**RE: CONCEPT DEVELOPMENT APPLICATION (STAGED DEVELOPMENT) FOR
ALTERATIONS AND ADDITIONS (SSD 7693)
MULPHA AUSTRALIA LTD, INTERCONTINENTAL HOTEL**

I am a resident of The Astor apartment building, which is located at 123-125 Macquarie Street, in the block adjacent to the proposed development site. I strongly object to this proposal due to the following considerations:

View Analysis

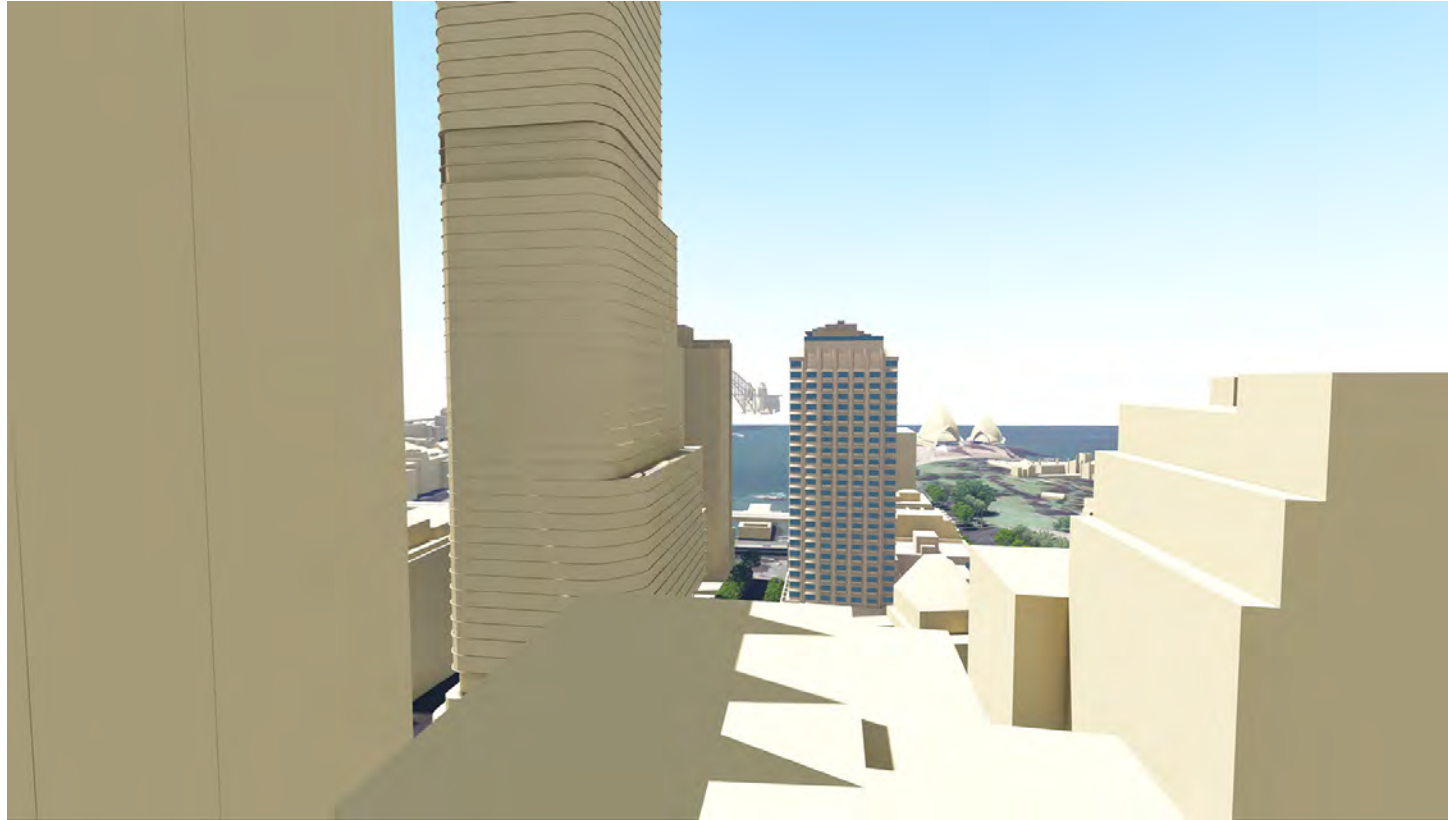
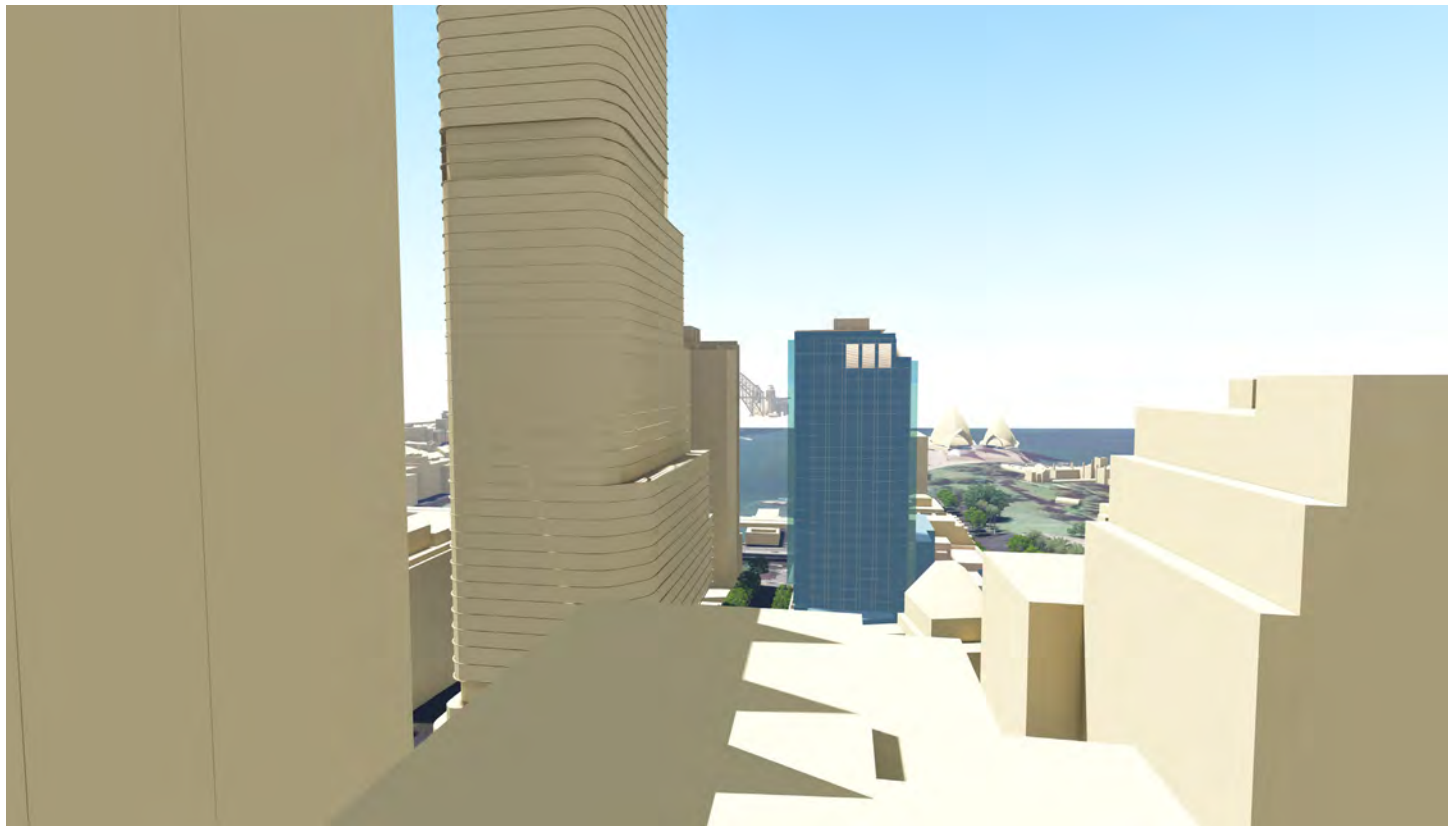
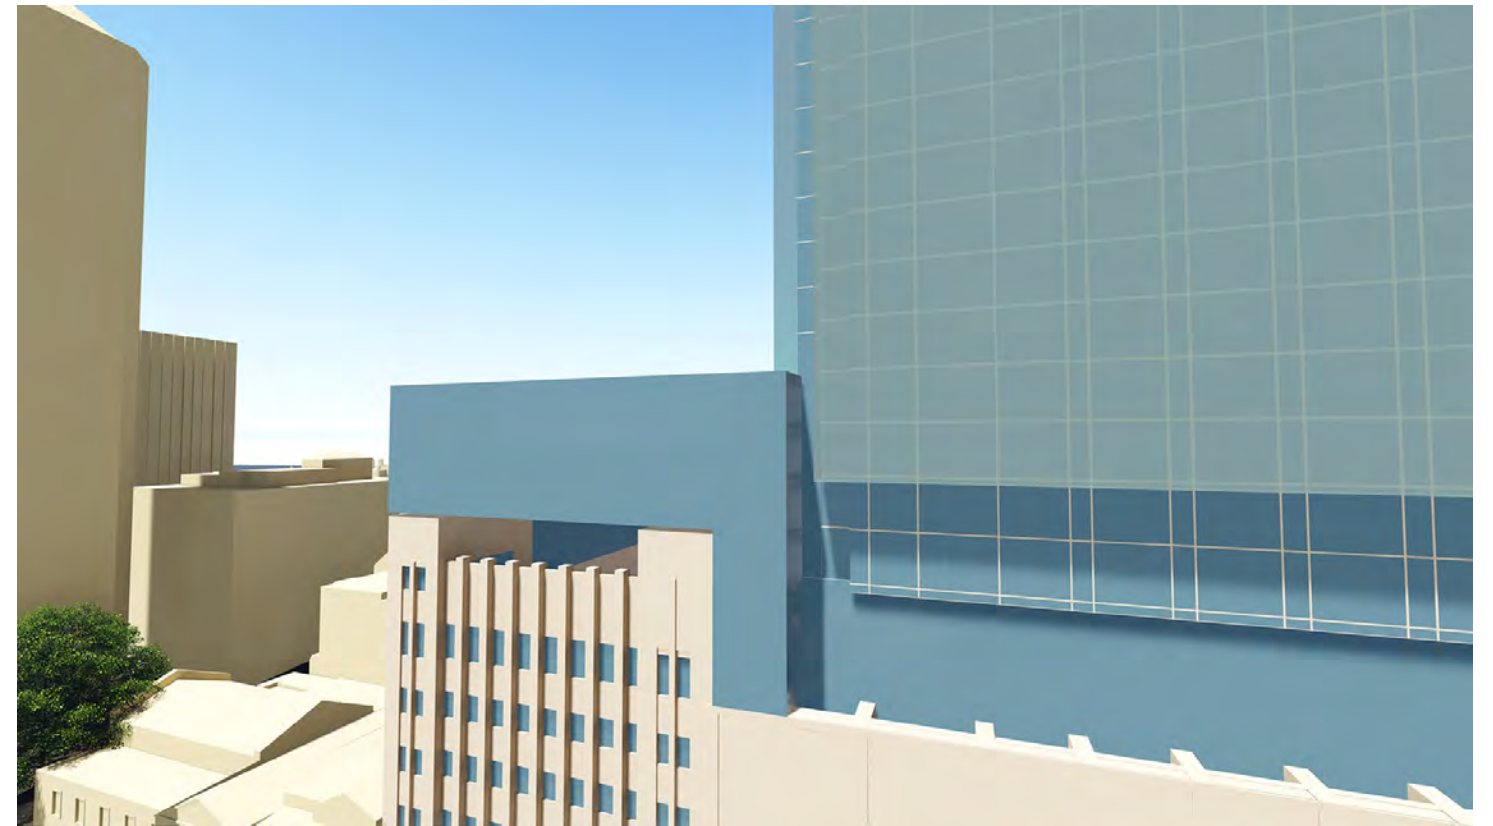
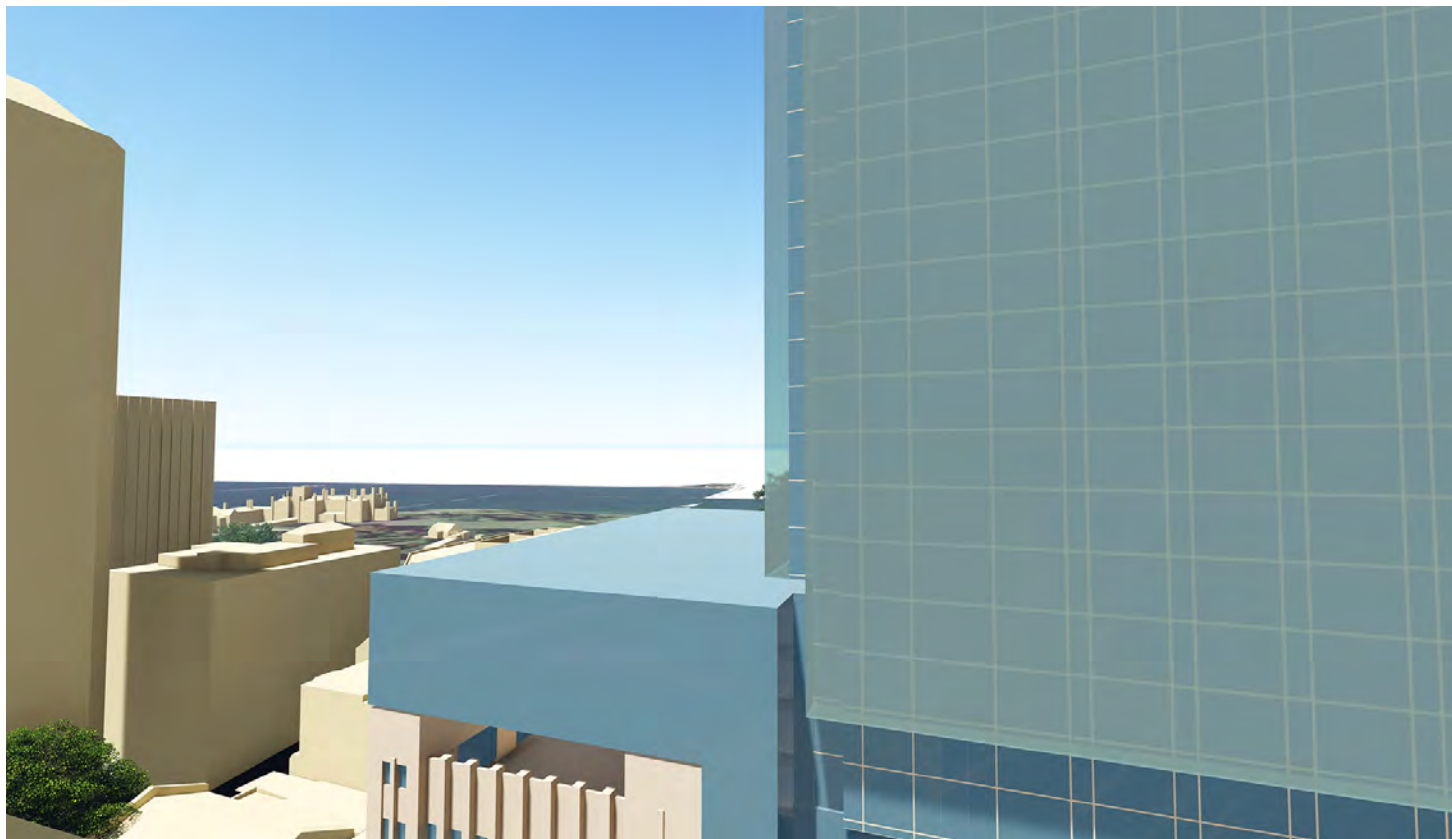
3. The proposal forces those in The Astor to surrender their existing views to the occupants of the new development. The View Impact Analysis incorrectly states that floors below Level 8 of The Astor will not be affected by the proposed building envelope. My apartment is situated on Level 7, and my views will be directly and adversely impacted by SSD 7693. The loss of these views is also not negligible, as they are my last remaining views of Circular Quay. I am happy to provide access to anyone to confirm this. The inaccuracy of this assessment is concerning, and raises the question of what other inaccuracies may be contained in the application. Further, the impact breaches the principle of “view sharing” established by case law. The InterContinental has already taken away iconic views of the Harbour Bridge from The Astor. To continue to allow for views from The Astor to be eaten away by this proposed development is inequitable.
